Crown Sydney Hotel Resort

Appendix A – Detailed Response to Submissions

Response to Agency Submissions

Figure 34 Bus services post 4 October 2015

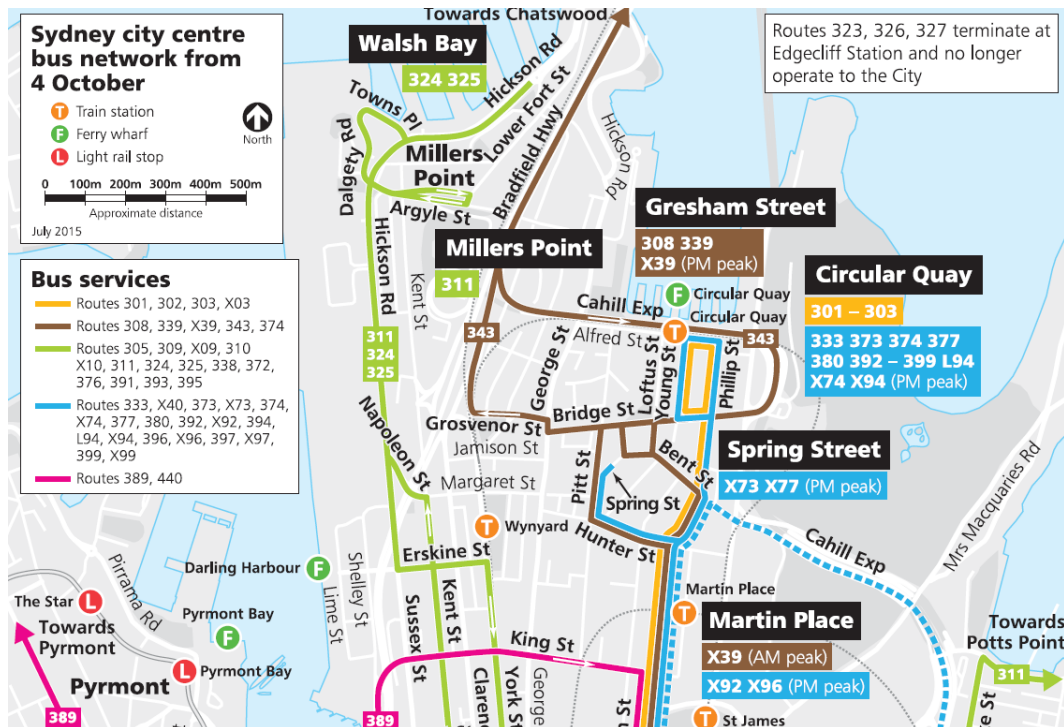
<ul style="list-style-type: none"> Assessment or consideration of bus movements in the area that were recently announced by Government to service Barangaroo and Walsh Bay from 4 October 2015 do not appear to have been considered. Traffic flow capacity along Hickson Road will need to be maintained to meet the prevailing demands, particularly with the activation of Barangaroo South and traffic light operations at the intersection of Sussex Street /Hickson Road/Napoleon Street. It is highly likely that new traffic lights will be operating in Hickson Road at other intersections in future and the Hickson Road remediation works will potentially impact capacity. The impacts of these will need to be considered to ensure that impacts on access and Hickson Road operations can be suitably managed. 5.30.4 stipulates that traffic control at personnel controlled access points will be done so in accordance with Condition of Approval D4(c) of MP10_0023. This condition refers to a maximum of no more than six vehicles being queued at an access point. The dynamics of the network and area have changed considerably since this condition was written and it is not considered to be an appropriate impact any longer, particularly with traffic lights and through connecting roads in place in an operational Barangaroo South development. Queuing should not generally be permitted in Hickson Road. Further, it will not be possible to queue vehicles in Hickson Road when site remediation of Hickson Road is being undertaken as per SSD14 6617. 	<p>Section 5.3 of the document has been updated to consider bus movements in the Barangaroo precinct.</p> <p>Noted. A cumulative traffic assessment has been undertaken which considers the impacts of the Crown Sydney construction project in the context of ongoing works within the Barangaroo and Wynyard precincts. This assessment concludes the Crown Sydney construction works will have a negligible impact on the operation of the road network compared to the current environment. Refer to the updated Traffic Assessment Report at Appendix E.</p> <p>Noted. Where practicable, no truck queuing is to occur on Hickson Road.</p>

### 3.3 Loading dock design

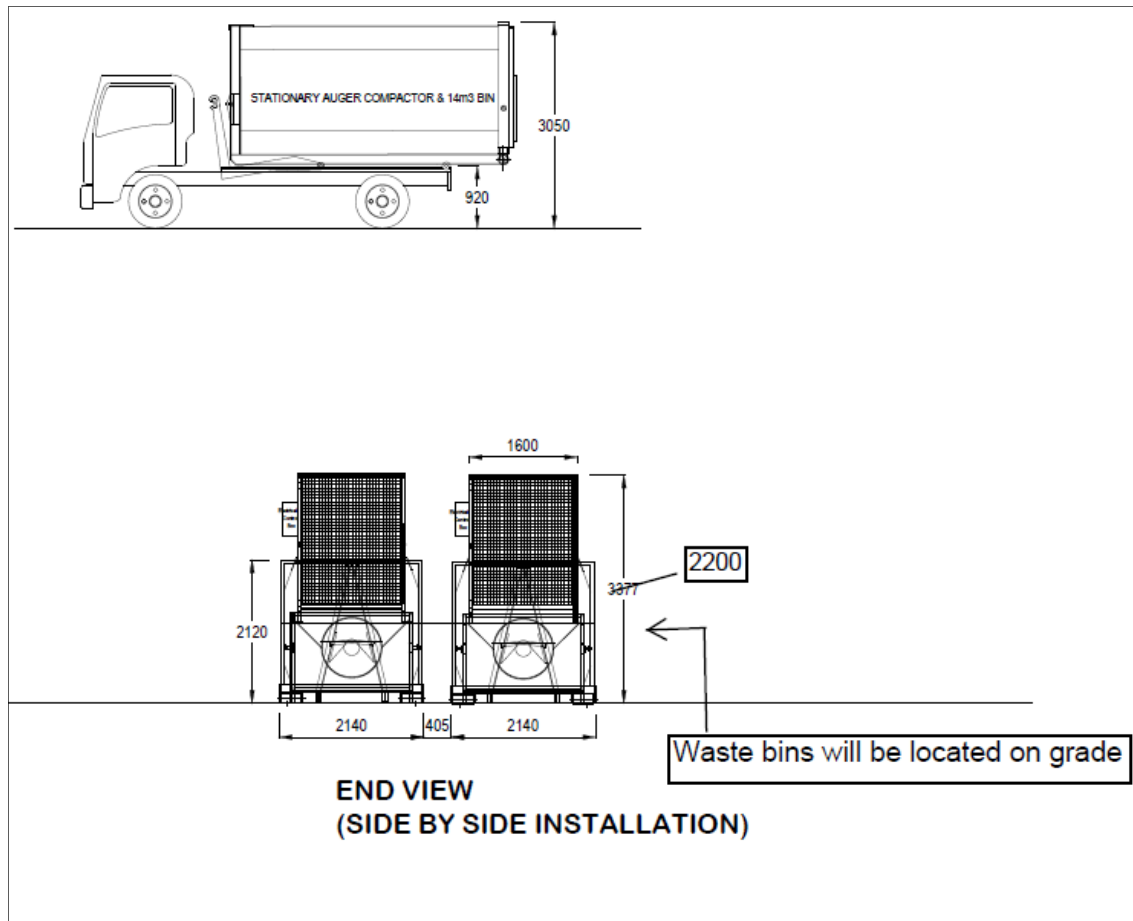
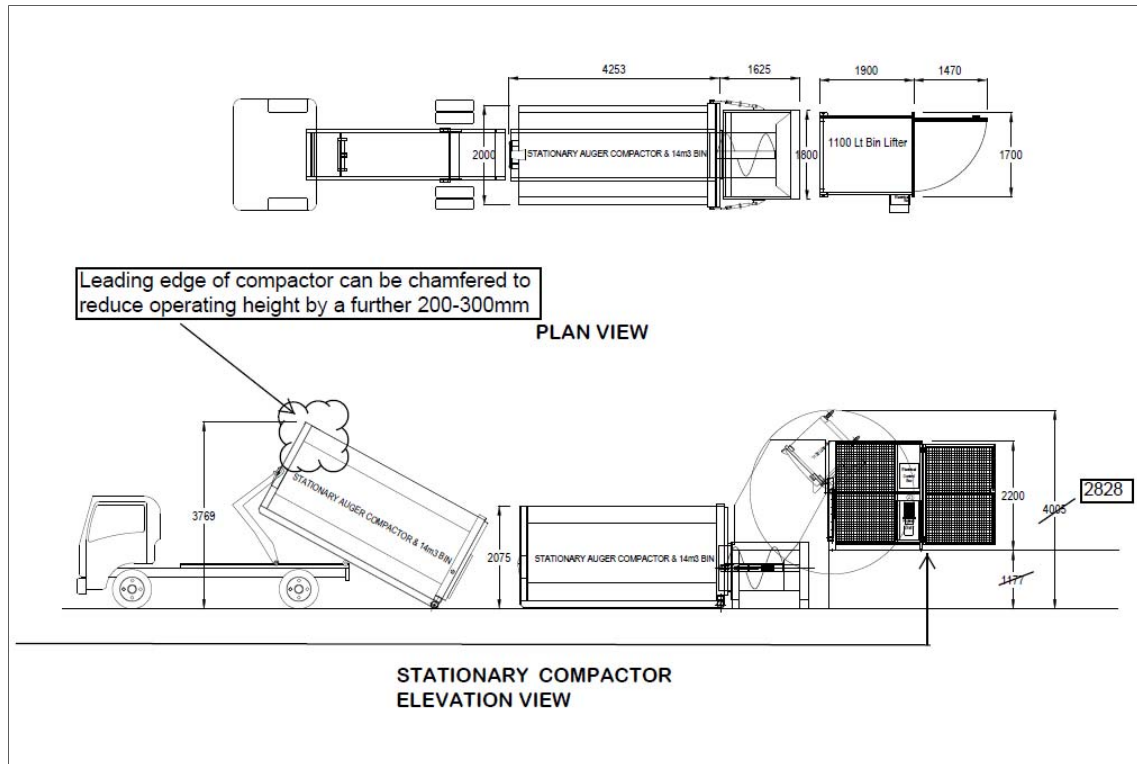
Parking <ul style="list-style-type: none"> The proposed parking spaces are double the allowance under the Sydney Local Environmental Plan 2012. The SSDA proposes 110 spaces for 66 apartments where 57 spaces would be the maximum under the City's controls. Restrict the 500 public car parking spaces being operated for commuter car parking Relocate Barton Street wholly within Barangaroo South or Barangaroo Central Establish whether the proposed loading dock has been adequately designed to accommodate waste vehicle collection. 	<p>Given the unique nature of the integrated resort, it was considered that the most appropriate method to forecast future traffic generation and parking demand is to refer to similar elements of the existing Crown resort in Melbourne. In this regard Arup (traffic experts for the project) were provided with parking and traffic data by Crown including both video surveillance footage and entry/exit data from Crown Towers Hotel porte cochere and valet operation. Through the use of this data Arup have been able to forecast with a reasonably high degree of accuracy, the likely traffic generation and parking demand created by the proposed development. Given the unique nature of the proposed development use of this methodology to calculate parking numbers is considered to provide a higher degree of accuracy than application of standardised parking rates under the Sydney LEP 2012.</p> <p>With regard to residential spaces, it is noted that the type of residential product on offer in the Crown Sydney Hotel Resort building will be high end luxury apartments. Many of the occupants of these apartments are therefore likely to require more than one car space. The proposed 110 spaces represent approximately 1.6 cars per apartment which is considered to be an appropriate reflection of the likely demand generated by the proposal. Further to this it is noted that parking rates are being addressed and established within the Concept Plan, which sets rates of 1.2 spaces/ 2 bed apartment and 2 spaces/ 3+ bed apartment.</p> <p>Relocation of Barton Street is not a matter for this application, but is rather a matter that should be addressed as part of Concept Plan Mod 8.</p> <p>The Crown Sydney loading dock has been designed to accommodate vehicles no larger than standard garbage trucks (medium rigid vehicles). A vertical clearance of 3.6m has been provided so that it is not possible for larger vehicles (e.g.</p>

<p>heavy rigid vehicles) to access the loading dock. Waste vehicles will however be able to access the dock and remove waste as required.</p> <p>Further details are provided in the Supplementary Traffic Response and updated Traffic Assessment Report included at Appendices E and H.</p>
	<p>Wind</p> <ul style="list-style-type: none"> Wind impacts from the tower are anticipated, based on the impact assessments in Concept Plan Mod 8 The wind assessment for the SSDA adopts a different approach to the wind assessment for Concept Plan Mod 8. The Mod 8 assessment speaks to safety and comfort criteria for able-bodied pedestrians and less able body pedestrians. The SSDA is more general and does not make distinctions between the user experiences of an able-bodied person and a person with a disability. Wind shield/skirts should be incorporated into the built form of the tower and podium to address downdrafts on both the privatised and public areas of the base. 	<p>An assessment of pedestrian wind impact has been undertaken for the proposed development by RWDI and was provided with the application. Wind conditions for the proposal were assessed through detailed wind tunnel testing that involved 93 specifically designed sensors that were connected to the model and which reported back to a wind data acquisition system to record wind conditions surrounding the proposal. Wind testing was then taken from 36 different angles to ensure a thorough analysis of potential wind conditions in all environments. Measurements were then taken to evaluate pedestrian comfort at building corners, near building entrances, on adjacent pavements with high pedestrian traffic, and in open plaza areas. It is noted that the report prepared for the Crown Sydney Hotel does not differentiate between able bodies and disabled persons, but rather assesses and discusses the impacts on 'pedestrians' in a broader sense.</p> <p>The results of this analysis indicated that the wind environment around the building is expected to be met at all locations with the exception of around the building's northwest corner, where summer winds from the north-east and north north-east have the potential to result in elevated wind conditions that would affect the levels of pedestrian comfort. Mitigation measures we recommended in response to the elevated wind conditions including the addition of vertical wind control elements at the building's northwest corner, and the provision of landscaping along the promenade and to the north of the building. Both of these mitigation measures have been incorporated into the design of the proposal and as a result wind conditions in all locations will pass the relevant criterion.</p>
